From: Simon Power
Sent: 28 May 2009 16:49
To: Planning.Responses
Cc: Jonathan Parsons; Brian Holland
Subject: RE: Planning Consultation on: AL/27/09/DOC at The Homestead

APPLICATION AL/27/09/DOC

Site The Homestead Westergate Street Westergate

Description of Works: Application for discharge of conditions no's 2, 3, 5, 8, 9, 10 & 11 in relation to AL/23/06.

TYPICAL AQUACELL INSTALLATION (INFILTRATION METHOD)
(Scale 1:20)

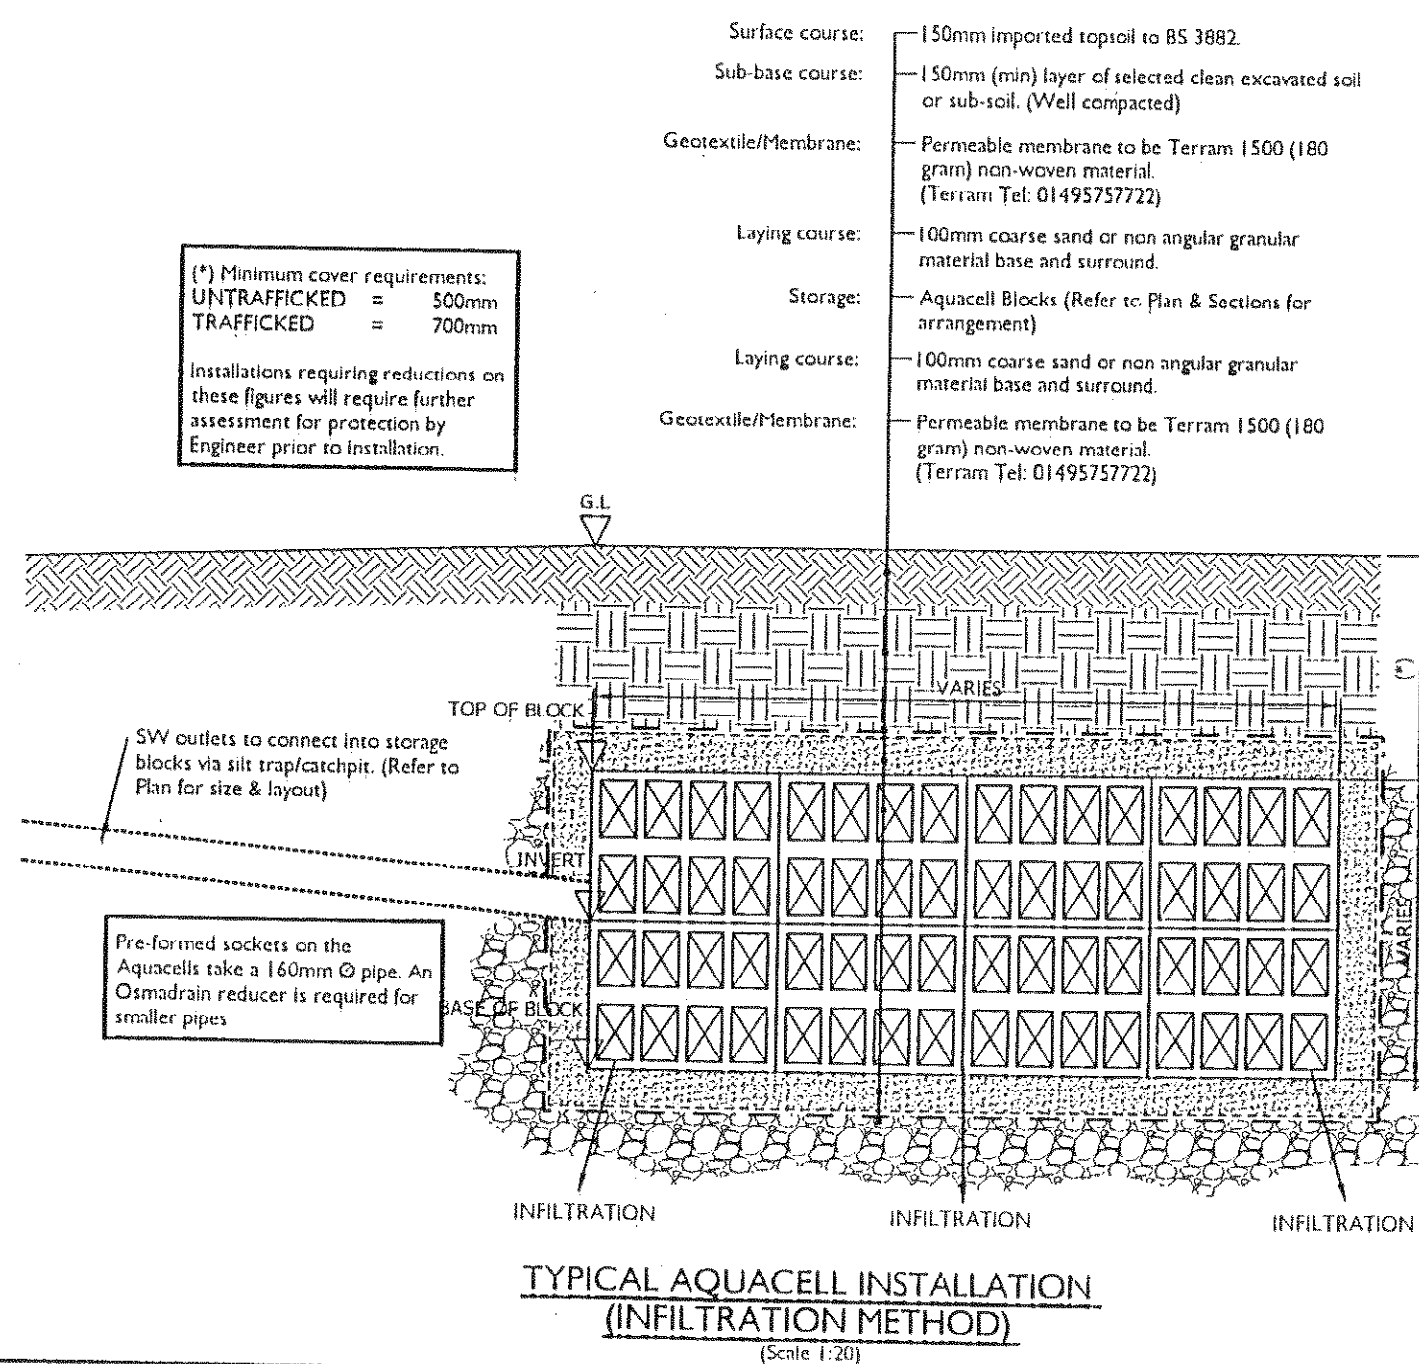
Details of the trial pit soakage tests together with calculations that determine the infiltration rate at the location of each proposed soakaway must be supplied, as recommended in BRE 365. Assumed infiltration rates are not acceptable.

Twelve months of on site groundwater monitoring data must be provided (so that the wetter winter months are included), which shows that the highest position of the groundwater table will not rise to a level above the base of each of the constructed soakaways.

The details of any maintenance arrangements (and who will be responsible for the system) are to be provided. This being to ensure the future efficient working and monitoring of the soakaways for any silt build up and removal.
